**Special Standard
 PUD Zoning District**

**CCES
 Responses**

Project Name: Villages at Sterling Ranch

PCD File No.: PUDSP-226

PRIVATE ROAD (30' WIDE TRACT)

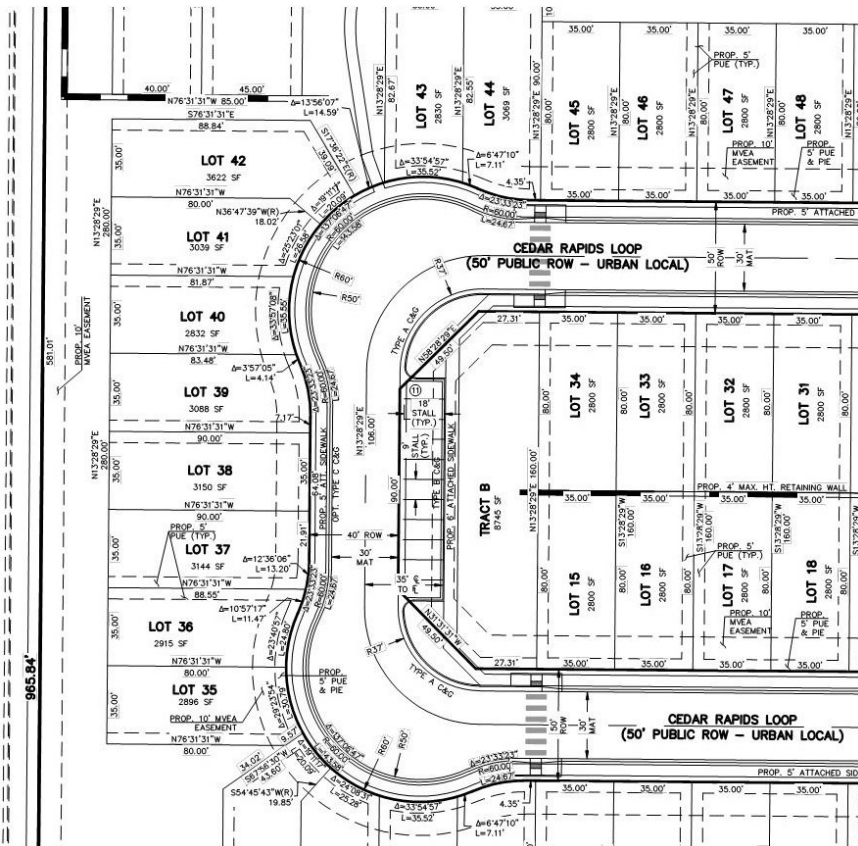
These 1 items can be removed as they are changes to the LDC. ECM administrator does not approve/disapprove LDC requirements, only ECM. Removed item 1

- LDC 8.4.4 (E)(3)**
Reason: **Removed 2 and 3 as well because the previous item 4 already discusses low volume road section and it also now includes the 40' ROW request.** Revise this one to reference low volume road standard and section is deviating from it.

- LDC 8.4.4 (C)**
Special Standards: **Public roads required – division of land, lots and tracts shall be served by public roads**
Some lots within this development will be directly accessed from private roads within a 30' wide tract. These specific lots will directly abut the private road tract that will be owned and maintained by the Sterling Ranch Metropolitan District. These private roads then connect directly with Public Right-of-Way.
- LDC 8.4.4 (E)(3)**
Special Standards: **Private roads to meet County standards**
Private roads functioning as an alley cannot meet all County public road standards, thus, the following represent the private road standards:

- 30' wide Private Road Tract owned and maintained by Metro. District
 - Pavement mat = 22.0'
 - Optional Type C C&G each side
 - Curb Return radius = 15'
 - Pavement design per County stds.
 - Design/Posted Speed = 20 mph

- No sidewalks or parking (Sidewalks provided to front of unit facing open space tract / Off-street parking stalls provided throughout site)
- Reference City of Colorado Springs Residential Alley Standard for similar criteria (Fig. 20, City of C.S. Traffic Criteria Manual)

3. LDC 6.2.5.C.3(g) Special Standards:

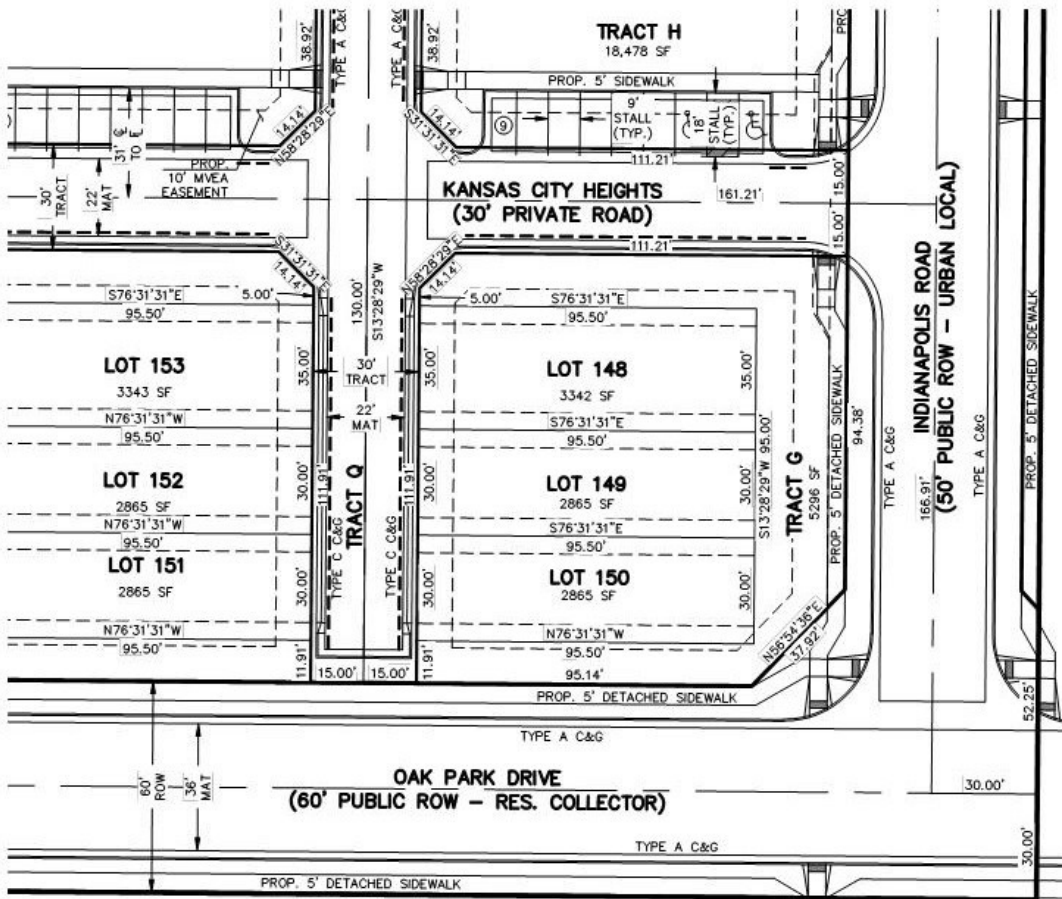
- LDC 6.2.5.C.3(g)**
Reason: **Revise this one to be a deviation to standard road section and ROW width will only be 40'.** that do public and
- ECM 2.2.4.B.7**
Reason: **Typical Urban Local (low volume) Road Section**
Private roads functioning as an alley cannot meet all the County public road standards for an Urban Local (low volume) Road.

Revise this one to be a deviation to standard road section, ROW width. (Just change section and title, I think the actual justification & exhibit are fine)

Now included in item 1

- 40' ROW adjacent to parking stalls
- 30' pavement mat remains consistent
- 20' parking depth provided to allow parking outside of public ROW
- Parking stalls within adjacent tract owned and maintained by Metro. District.

Fire Truck Turning Exhibit

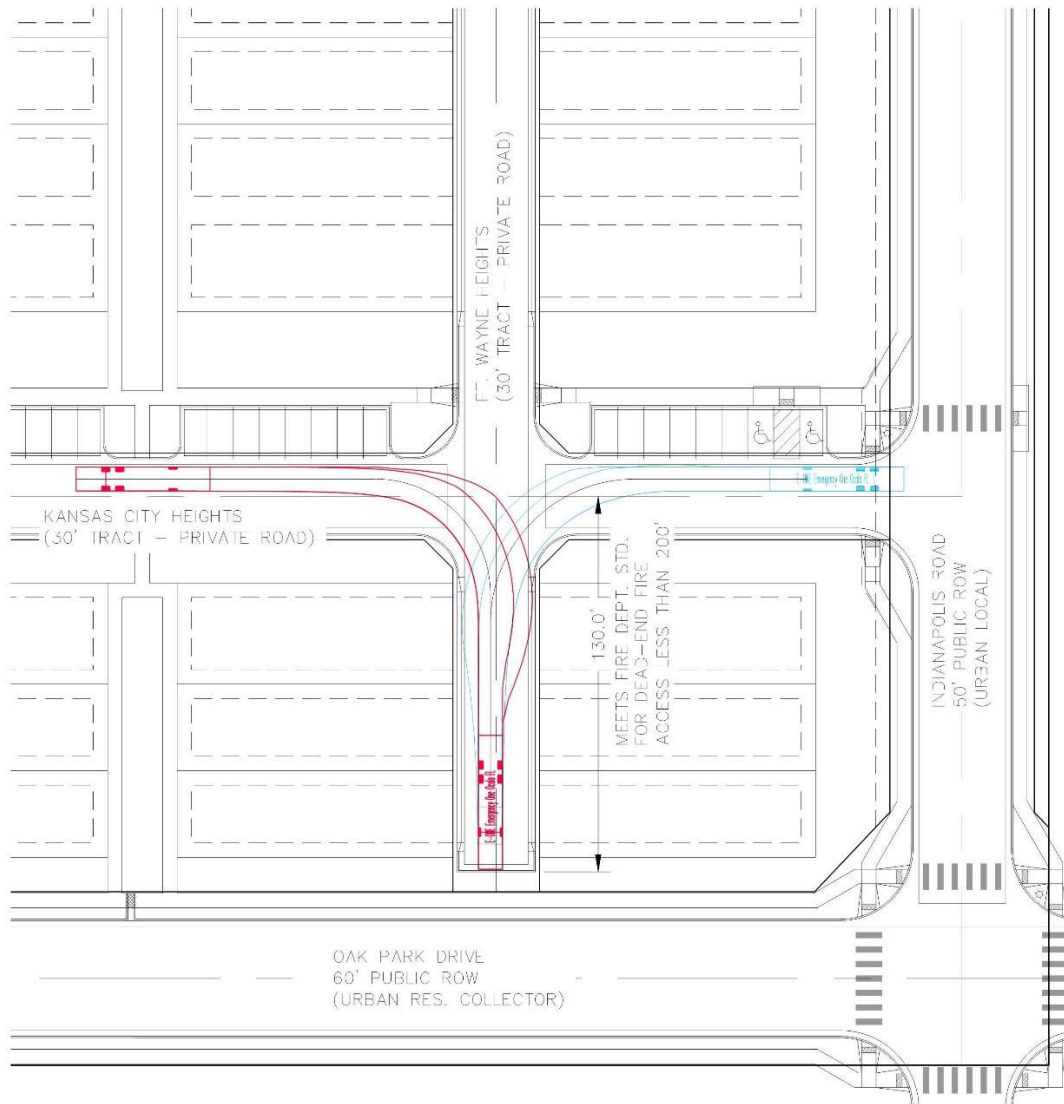
- ECM 2.3.8.A**
Reason: **Hammerhead turnarounds are not permitted as permanent roadway terminations**
This development includes access from private roads that provide turnaround ability for the residents and Fire District but not general public.
